S T U R M A N
A R C H I T E C T S

Date: October 14, 2021

Re: 9212 SE 33rd Place
Mercer Island, WA 98040

Subj.: Intake Response

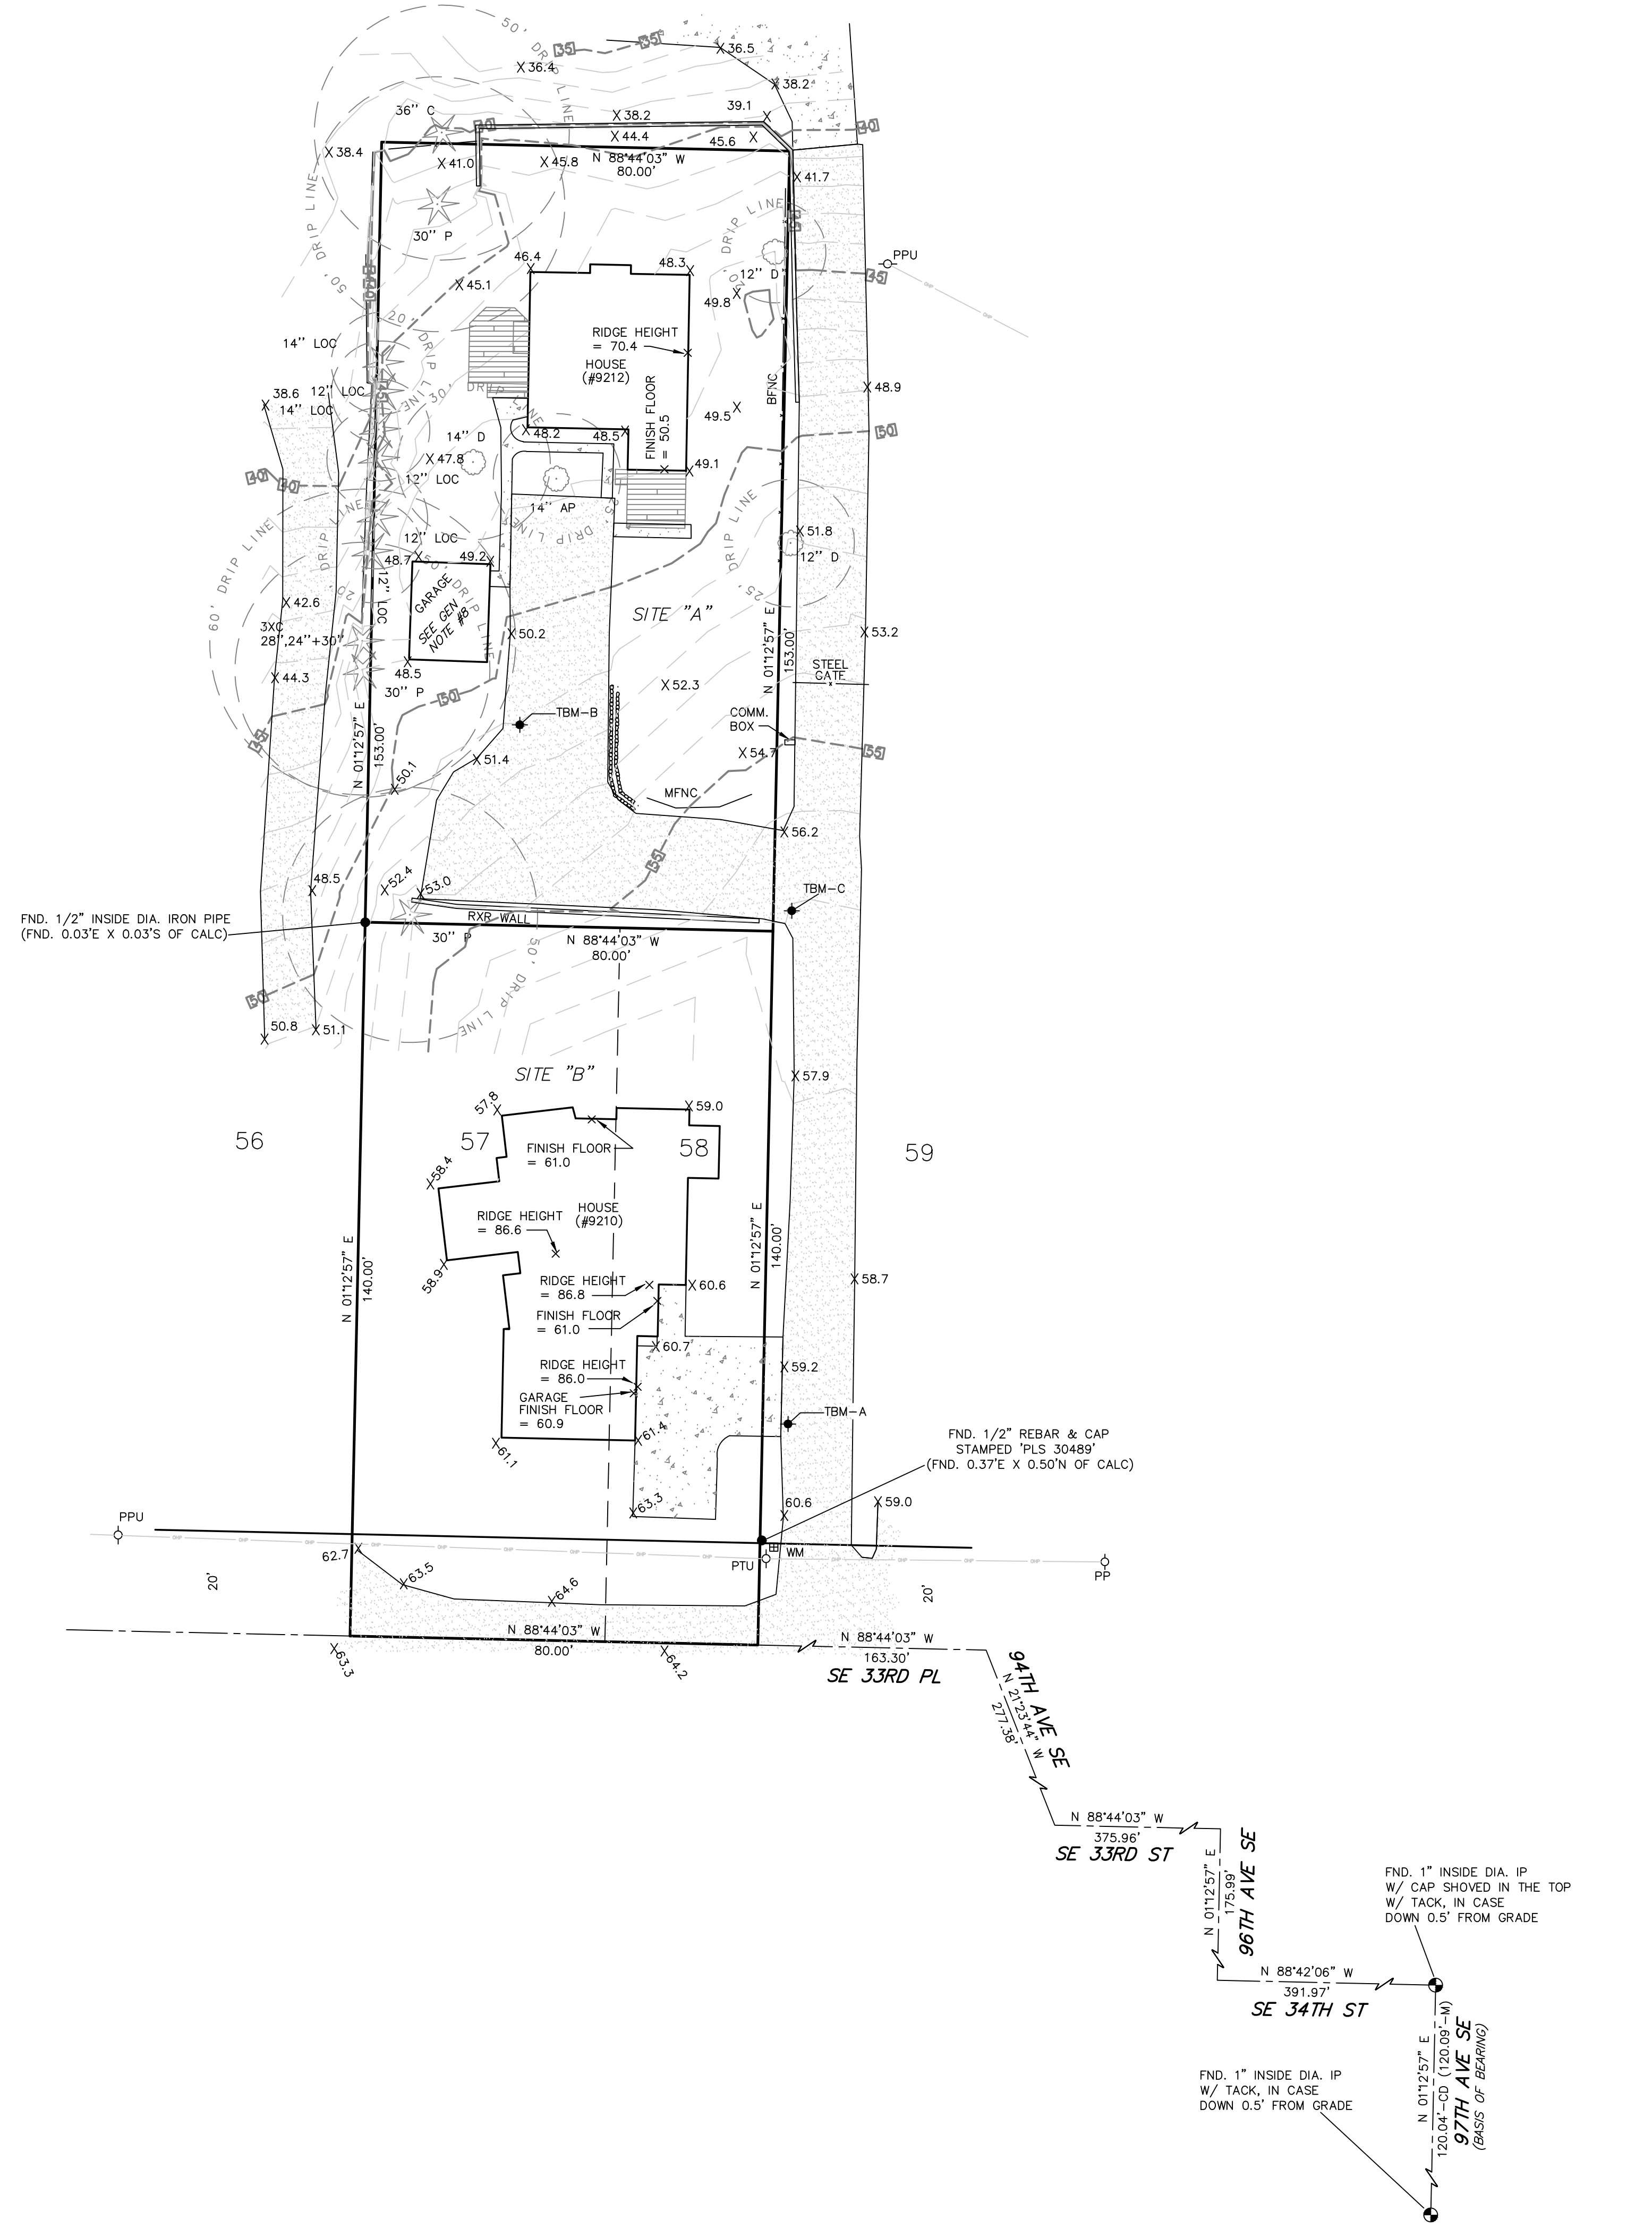
“In the Hardscape calculation table on Sheet A1.0, please show the 96.4 sf of allowable lot coverage that is being used for hardscape.”

“Please show the access and utility easement and associated recording number(s) on Sheet A1.0.”

Response: A column has been added to the Hardscape calc box showing the inclusion of this square footage from the Lot Coverage.

Response: The extent of easement, and its recording number, have been shown on A1.0. A copy of the easement has also been included in the Supplemental Materials folder.

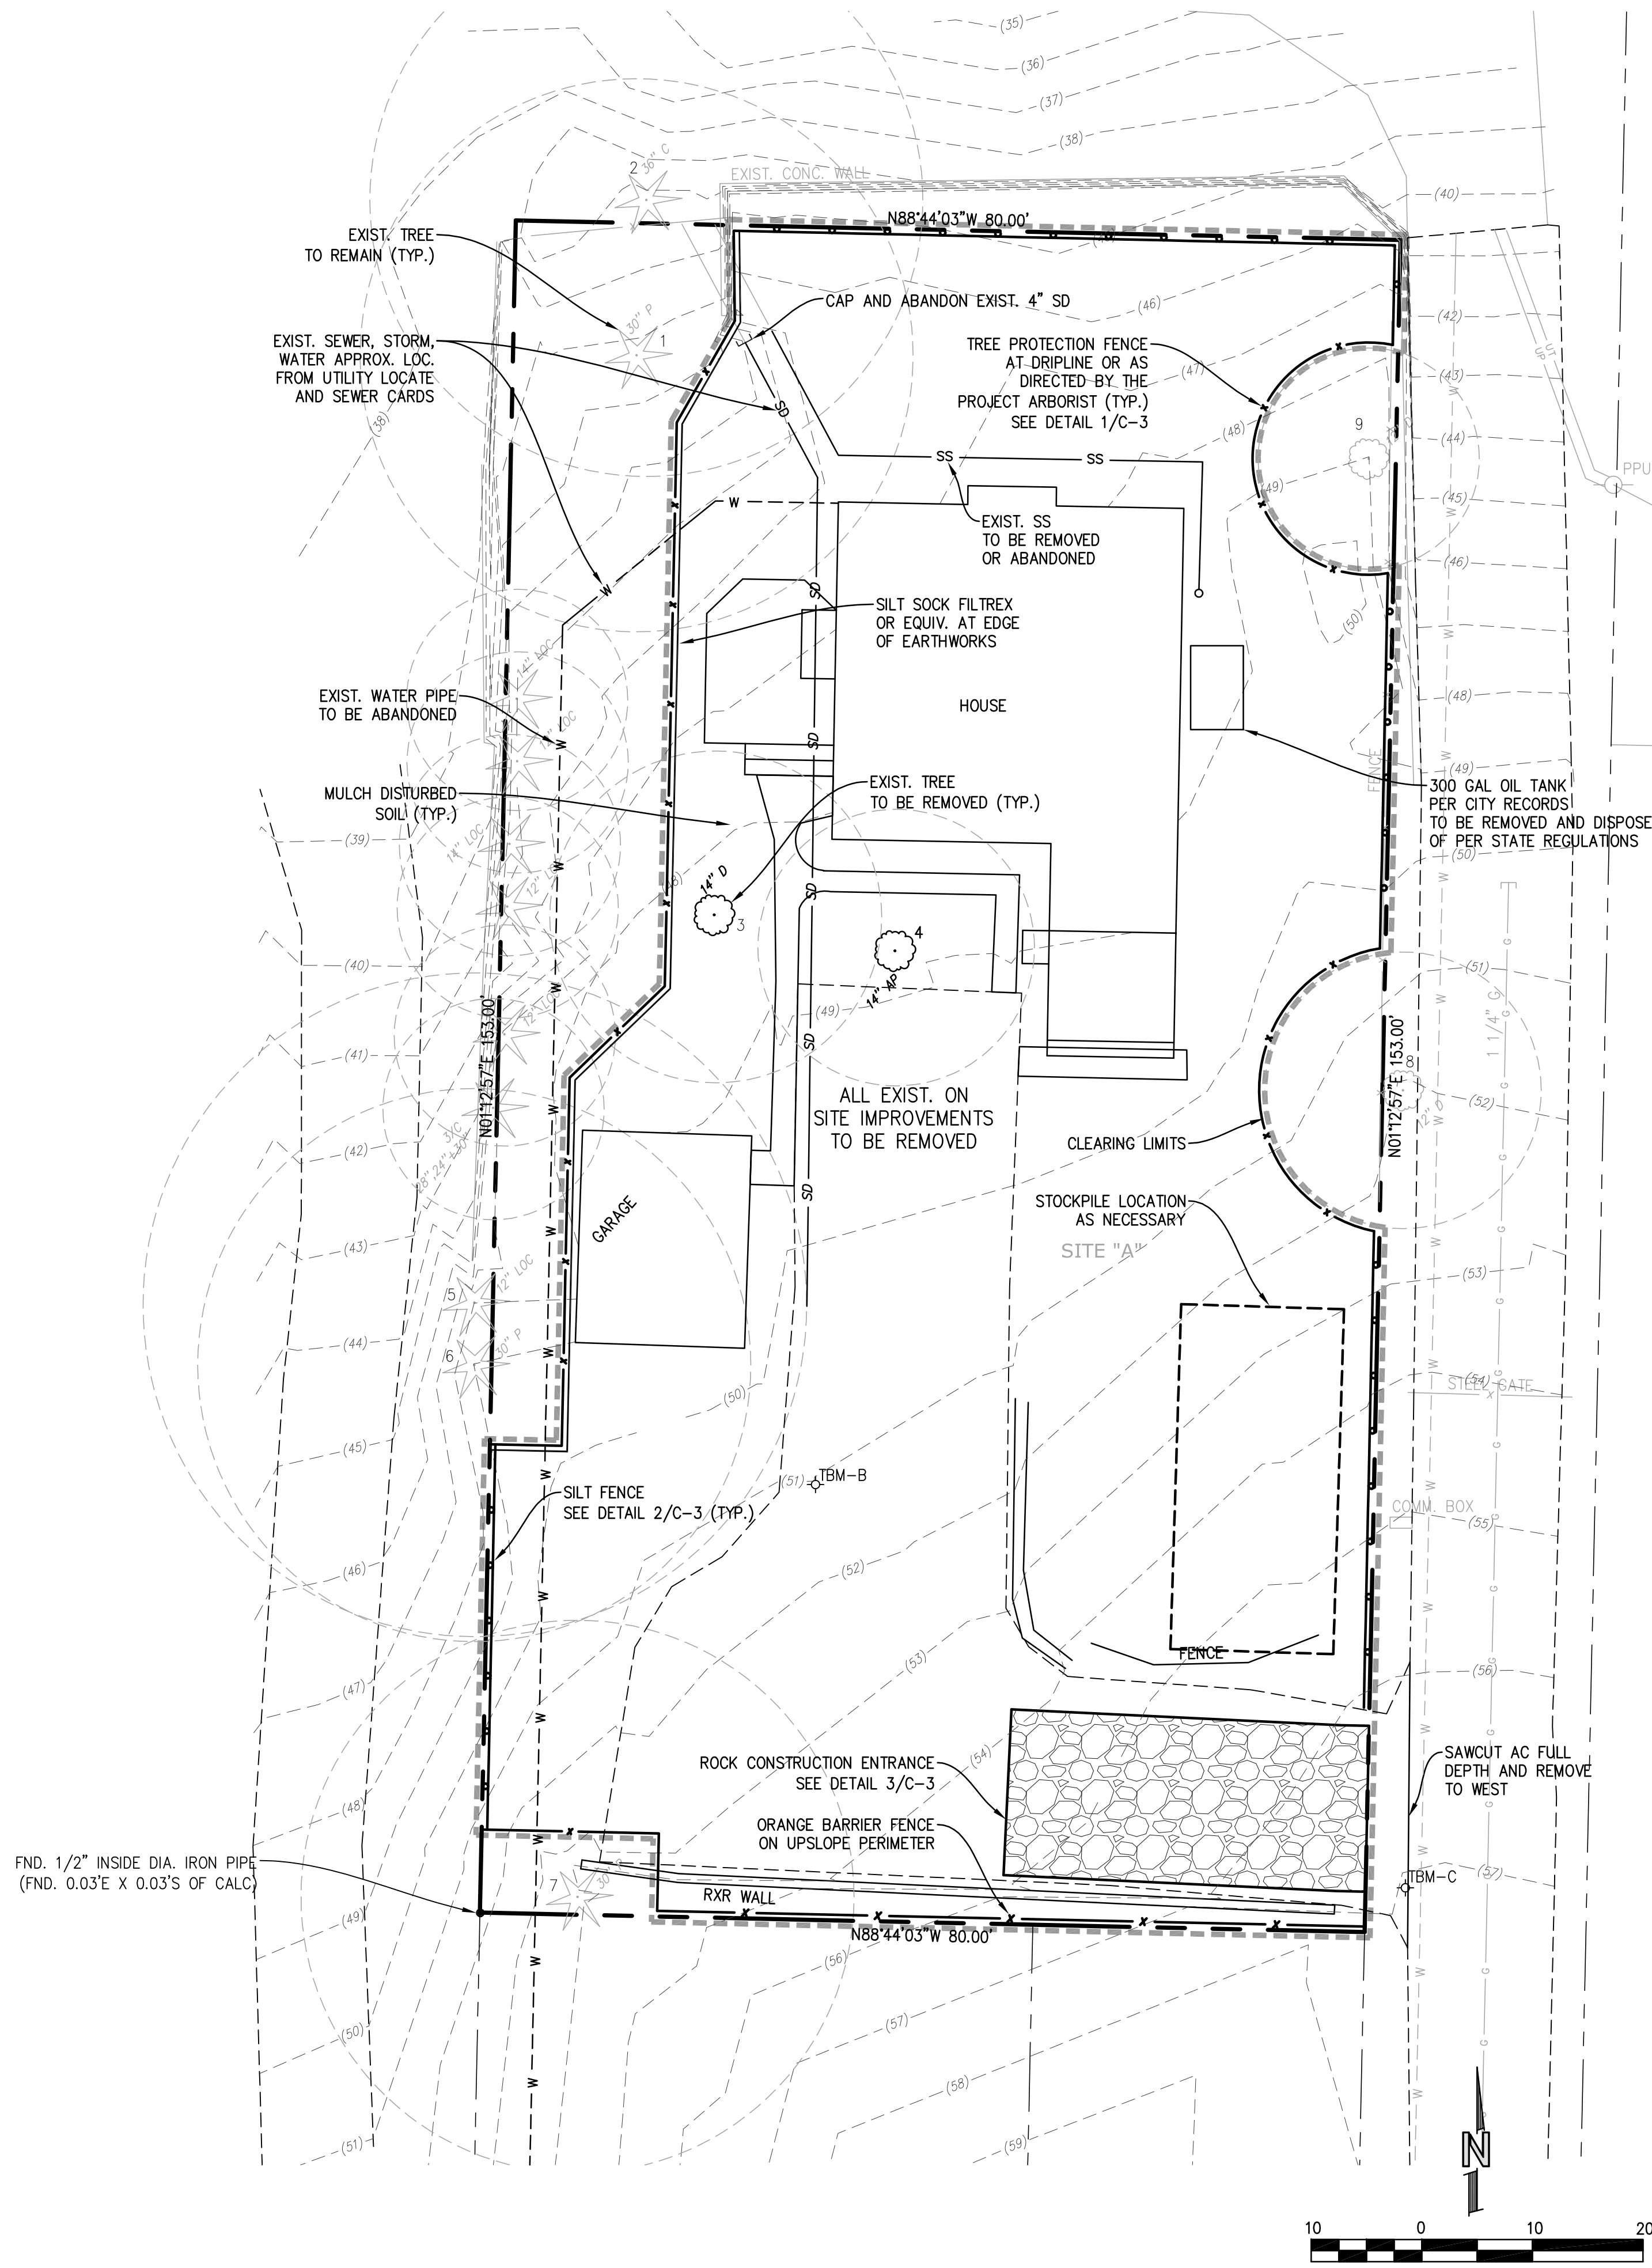
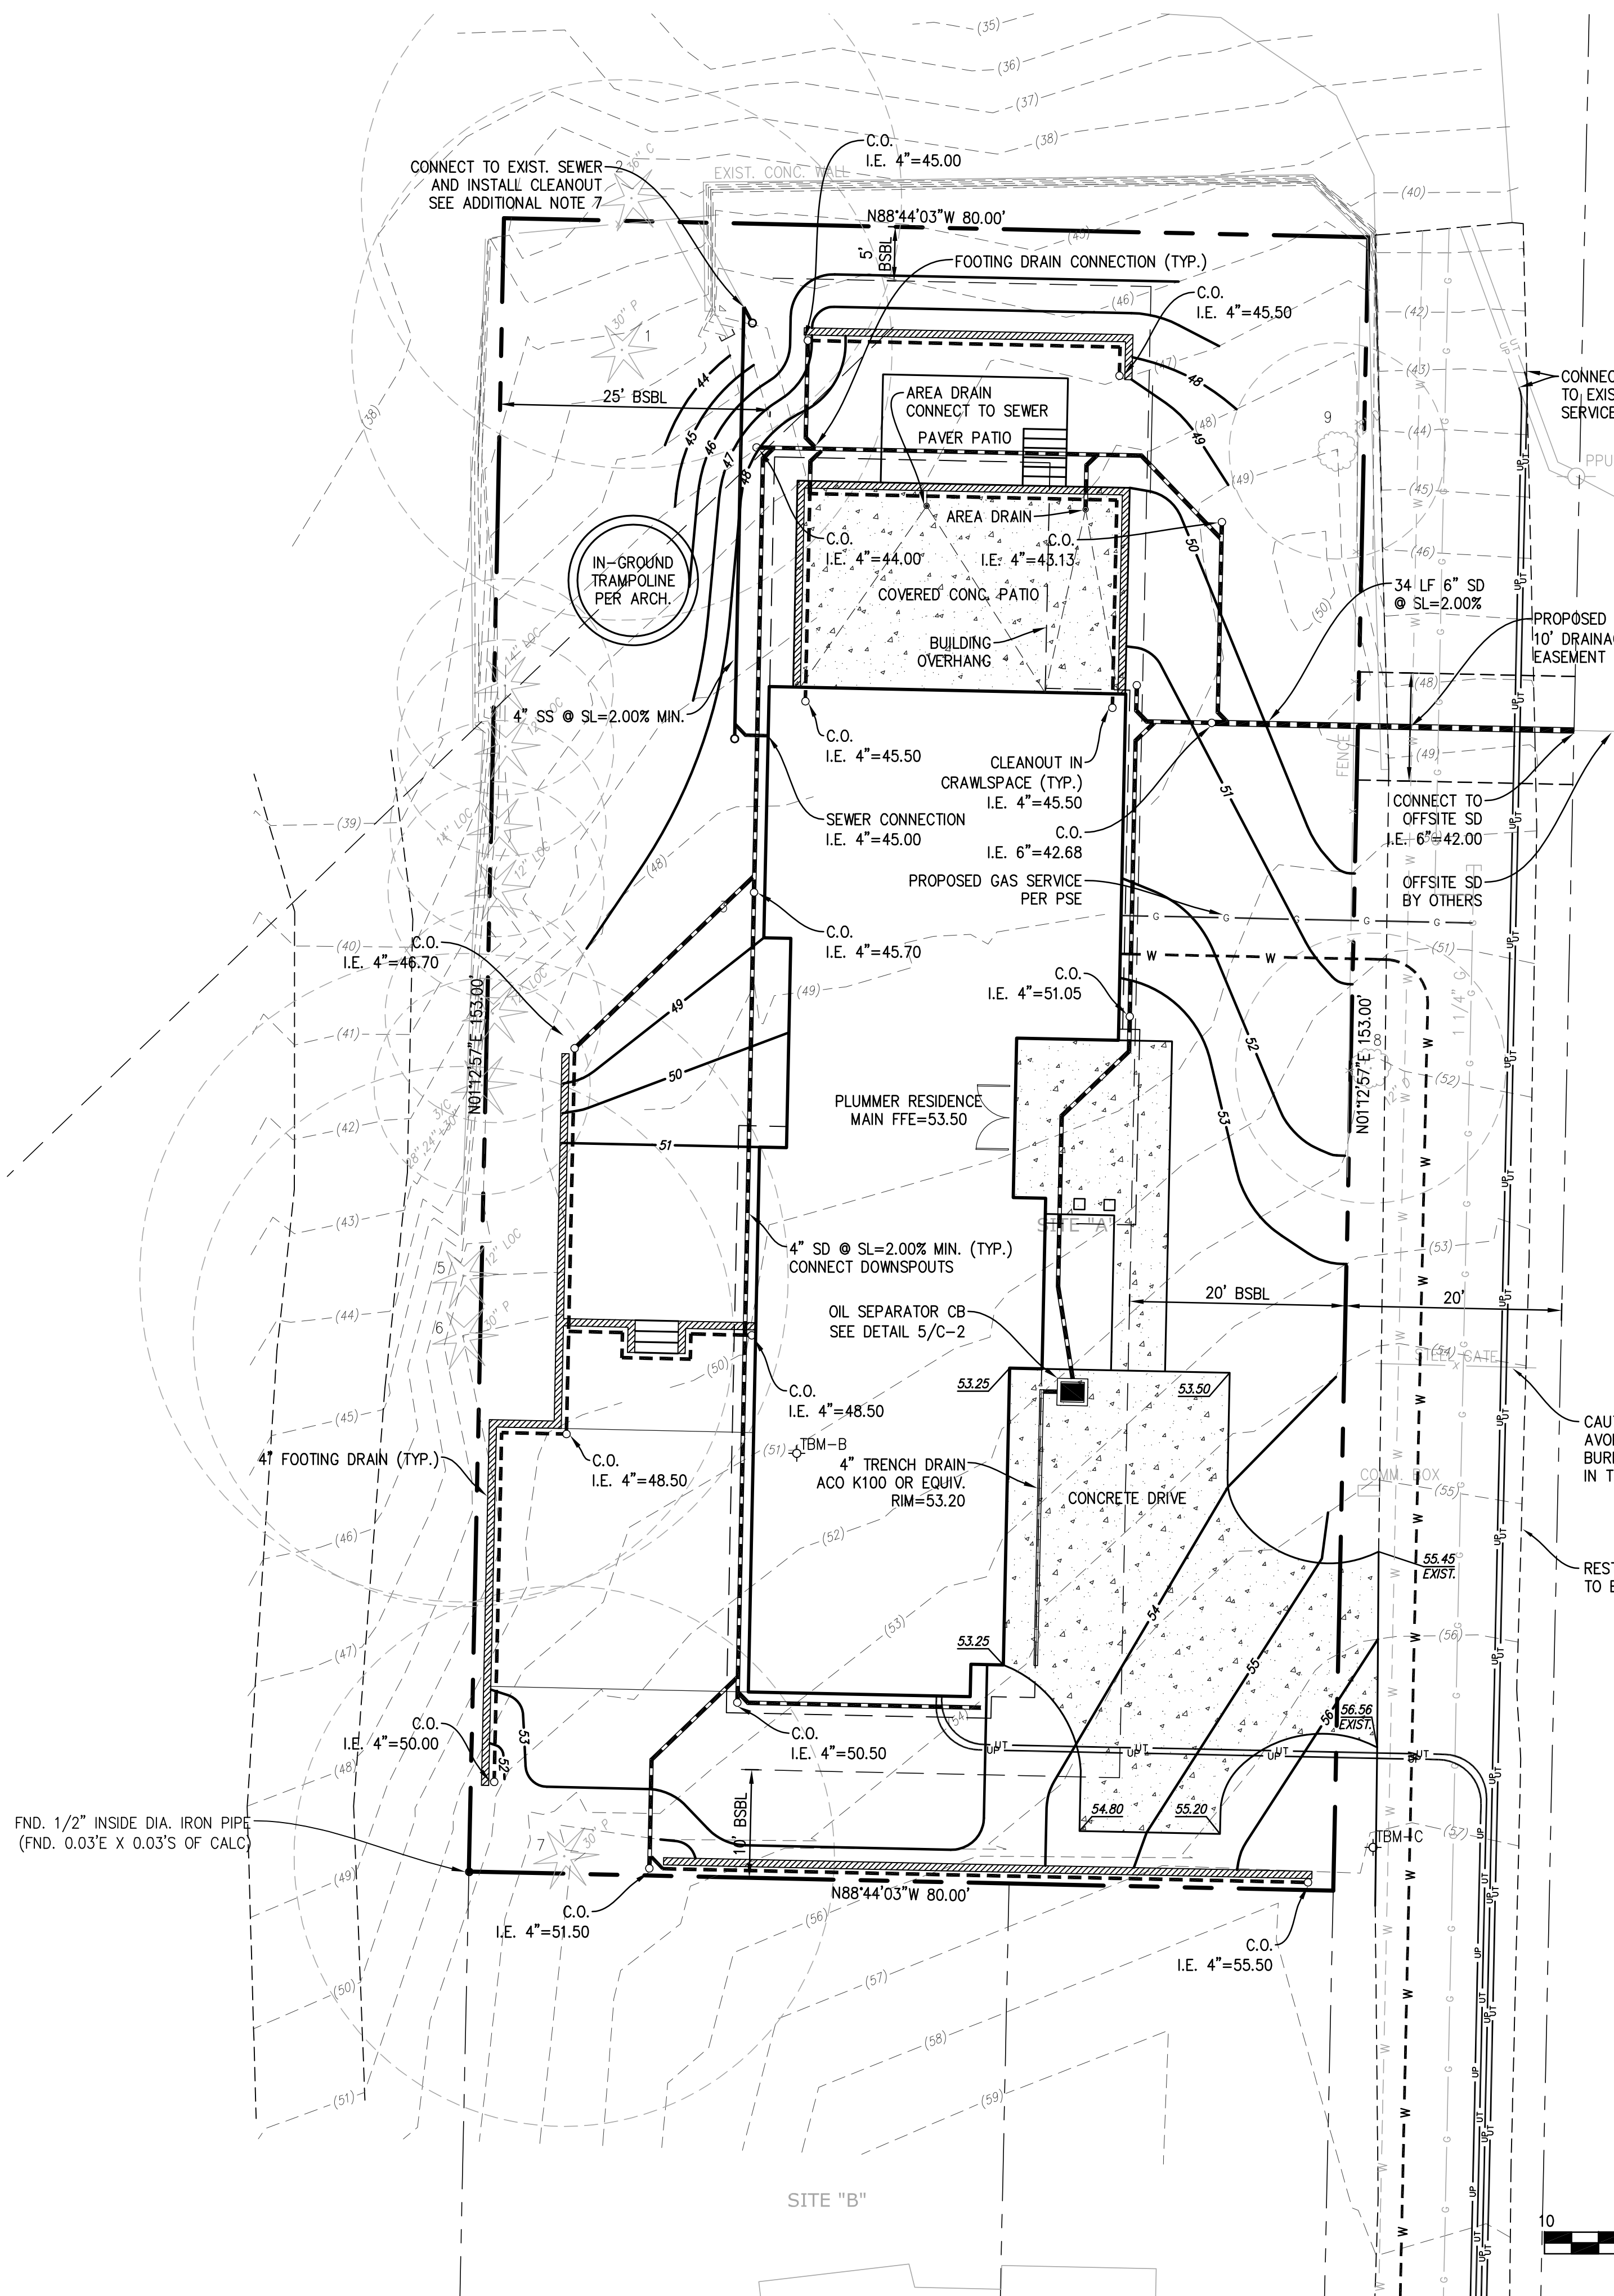
“The drainage plan shows the stormwater drainage for this project will be connecting to the neighbor’s drainage system (9222 SE 33rd PL). The drainage plan showing the entire drainage system (9222 SE 33rd PL) to lake must be included as a part of the plan set, and a written permission from the property owner of 9222 SE 33rd PL are required with the building submittal package prior to take in this building permit. A recorded easement is required prior to issue the permit.”

Response: Previously, the neighboring drainage plan was included in the Supplemental Materials folder. It has now been added to our drawing set, after our last Civil sheet.
